About the application

Application number: 2021/90672	
What is the application for?:	Prior notification for single storey rear extension
Address of the site or building:	2, Rumble Road, Dewsbury, WF12 7LR
Postcode:	WF12 7LR

PROPOSED REAR ELEVATION
Scale 1:100

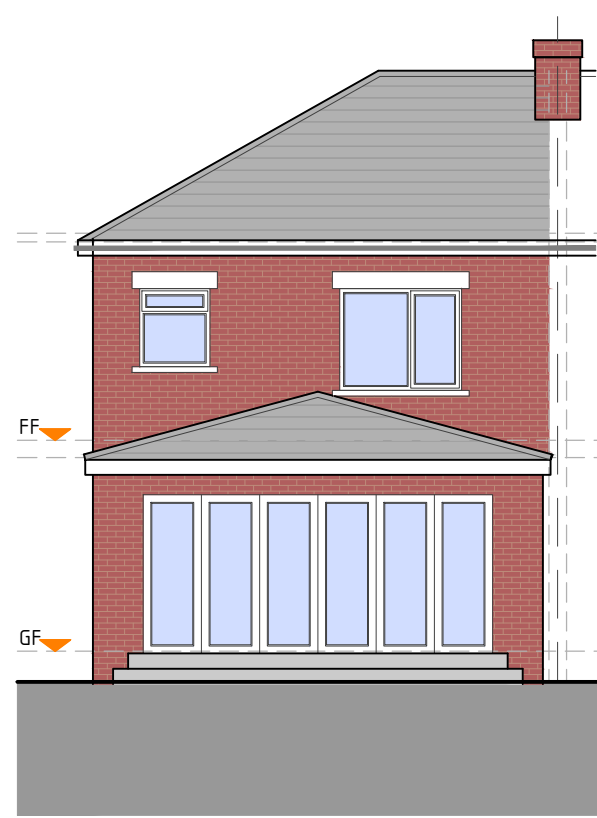
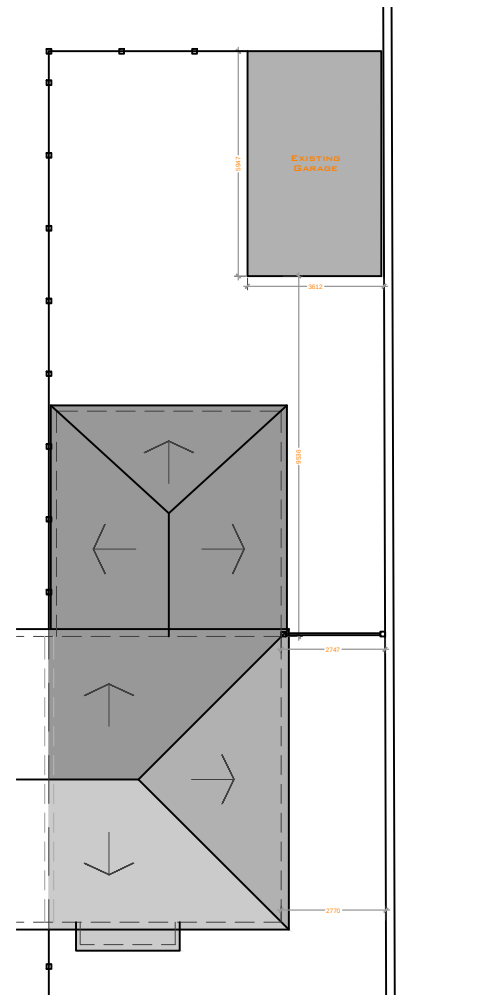
Type of comment: An objection	
Do you wish your comments to be published on the website anonymously?	Yes
I am submitting an objection to the proposed development and hope you strongly consider the below point 1) The window proposed in the side of the rear elevation, would result in overlooking of the neighbouring property and would result in a loss of privacy. There is no requirement for windows on the side of the rear elevation as the proposed plans show alternative means of light into rooms from rear windows/folding doors. To permit this would be contrary to LP24 of the Kirklees Local Plan and advice within chapter 12 of the National Planning Policy Framework; as detailed in previous planning applications for this dwelling. The proposed development is not acceptable for the reasons cited above Thank you
